| Application Ref: | 3/2021/0378 |  Ribble Valley Borough Council www.ribblevalley.gov.uk |
| DELEGATED ITEM FILE REPORT: | | APPROVED |

| Development Description: | Demolition of the existing stable structure and erection of a detached holiday cottage. |
| Site Address/Location: | Jersey Farm Knowsley Road Wilpshire Lancashire BB1 9PX |

**PROPOSED NORTH ELEVATION**  
Scale 1:100

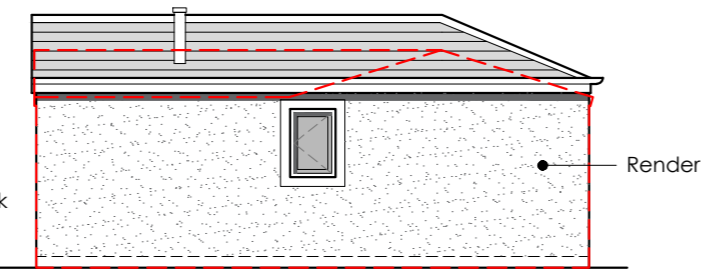
Taking into account the site layout, there would be potential for some loss of privacy between the north elevation of the proposed building and the facing windows of Jersey Farm given the lack of 21 metre separation distance.

Whilst it is noted that the proposed building is only of single storey height, there is a notable change in levels such that the north facing windows of the proposed holiday cottage would face directly into the first-floor windows of Jersey Farm.

Accordingly, there have been amendments to the internal layout and elevations of the building such that there are no windows of the north elevation. This arrangement ensures that there would be no harm to the residential amenity of permanent occupants of dwellings.

**PROPOSED SITE PLAN**  
Scale 1:100

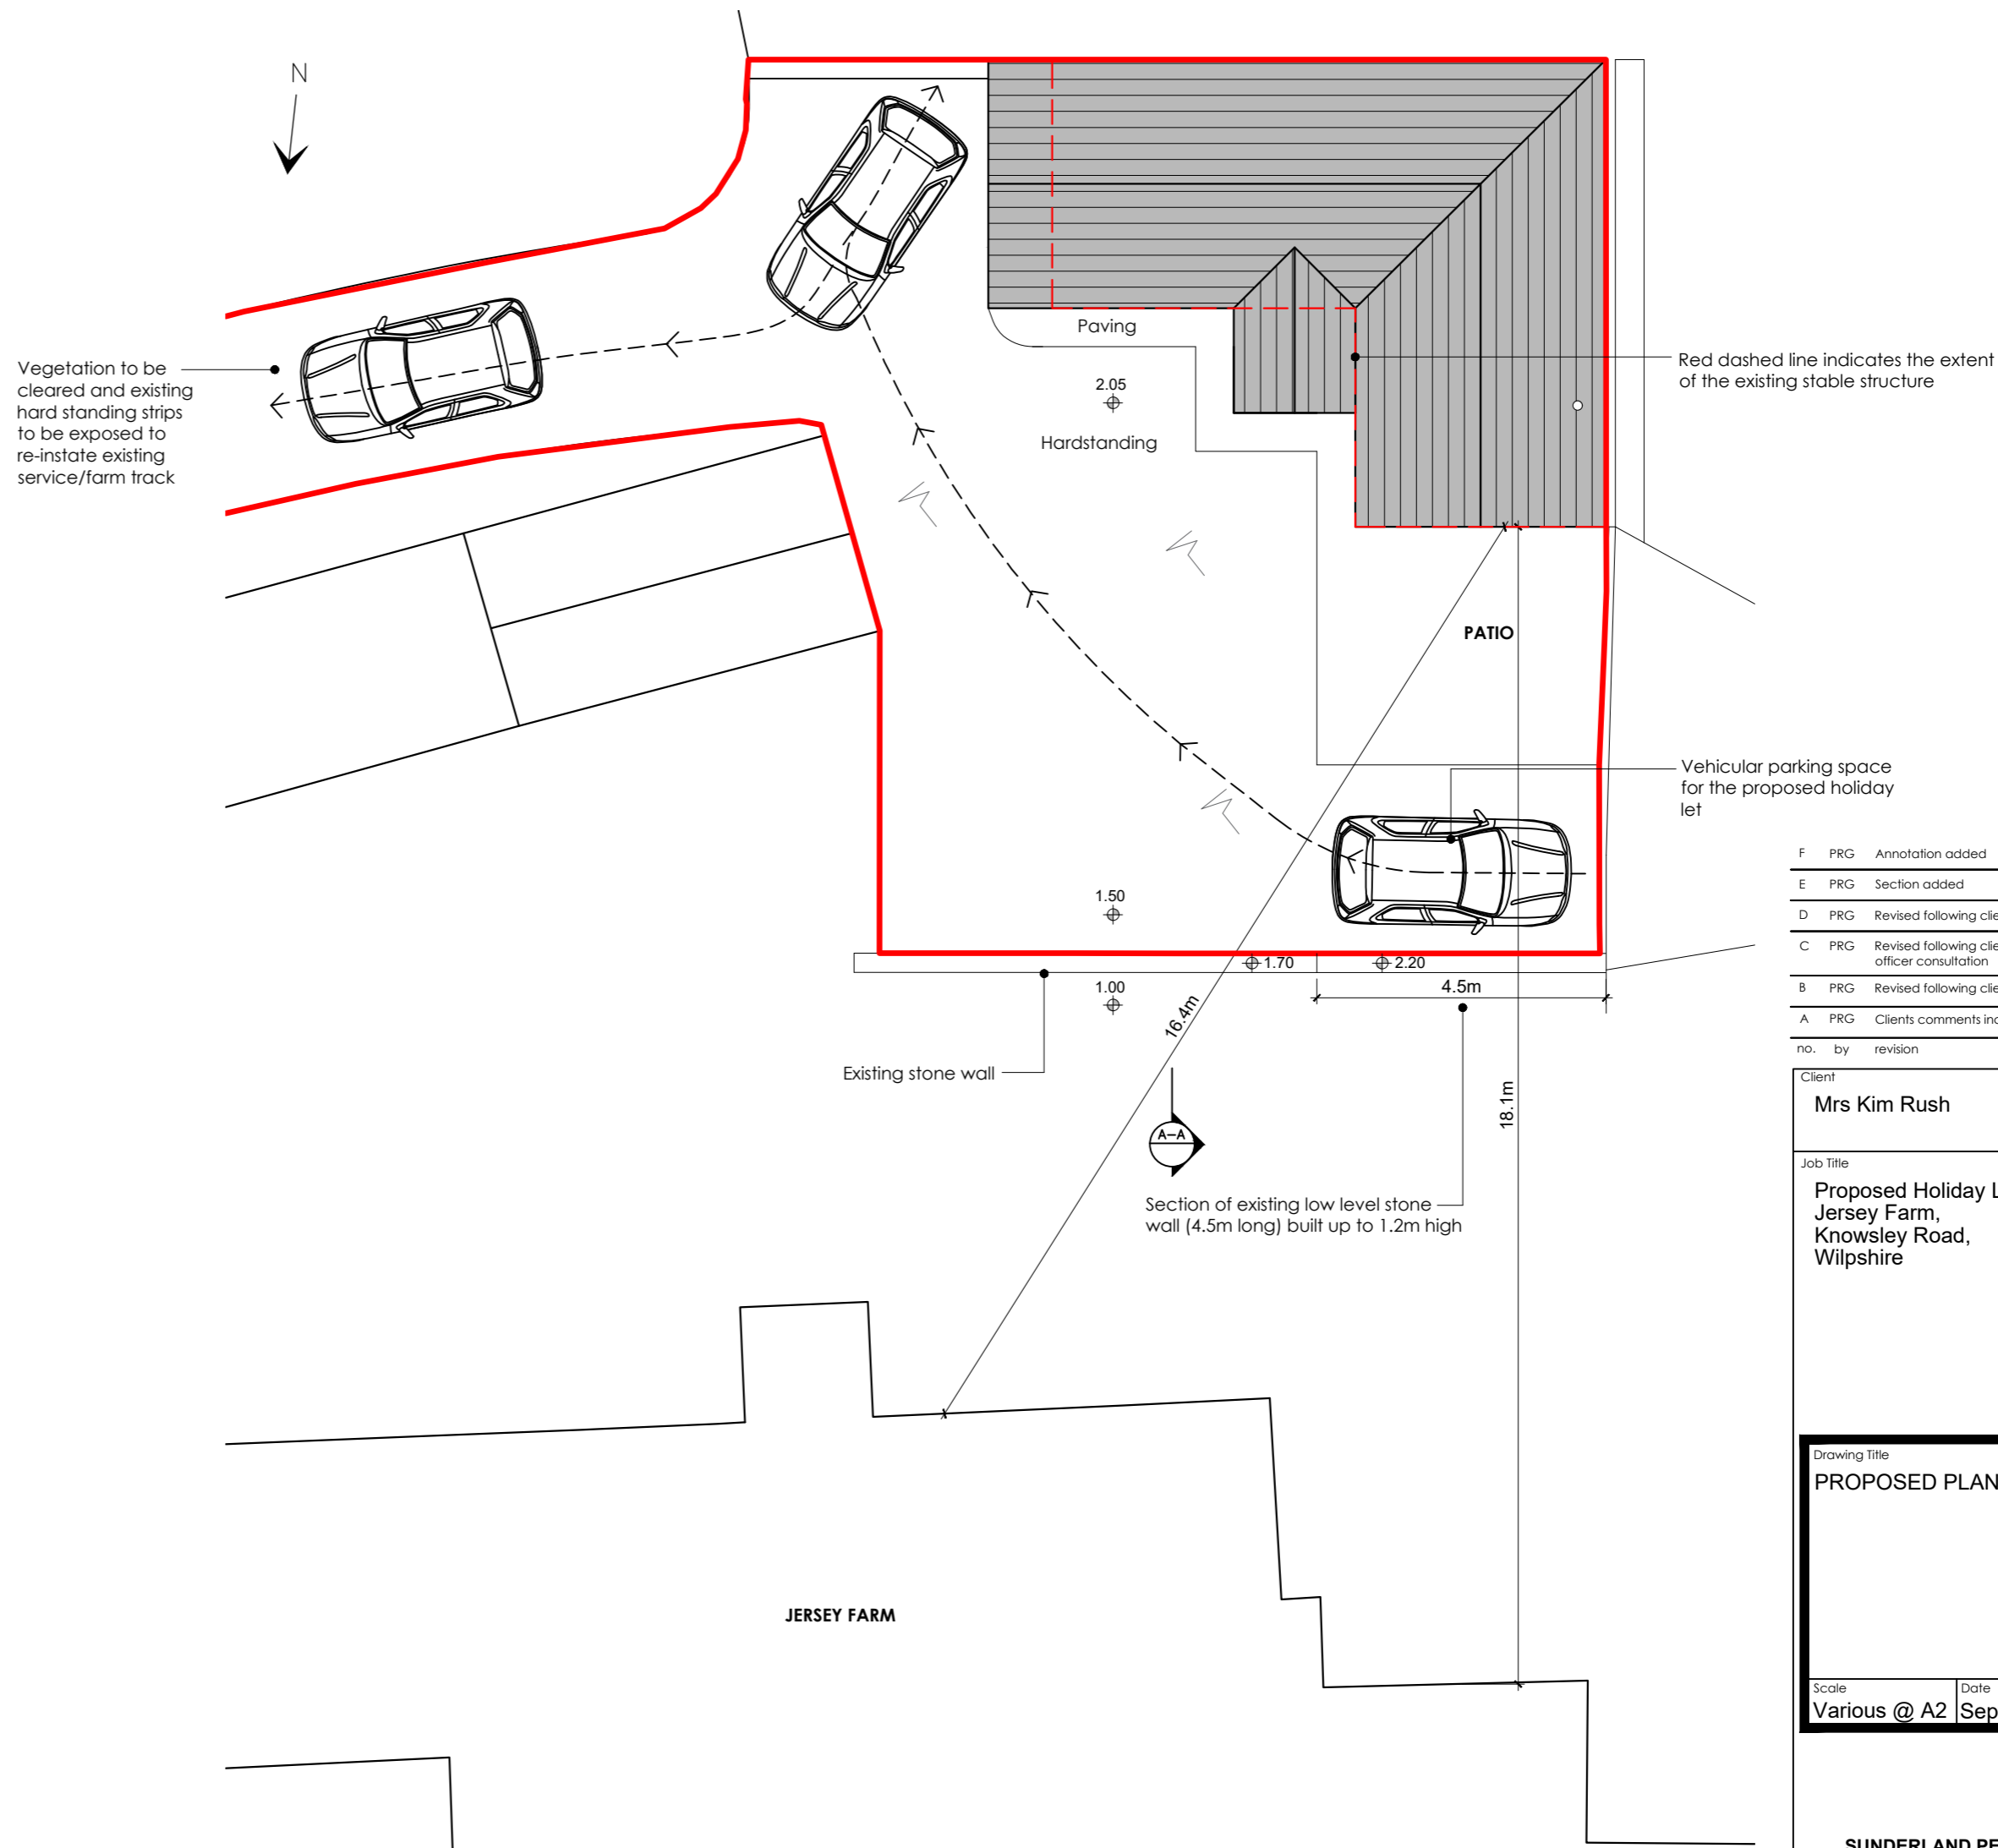
The proposal re-uses the existing hardstanding areas at the site and would require some relatively minor level changes within the site. As submitted, consent was sought to create a new access track that would extend from the existing track serving Jersey Farm. However, this has been removed from the proposals and it is now the intention that the proposed new holiday cottage would be accessed via the existing track.
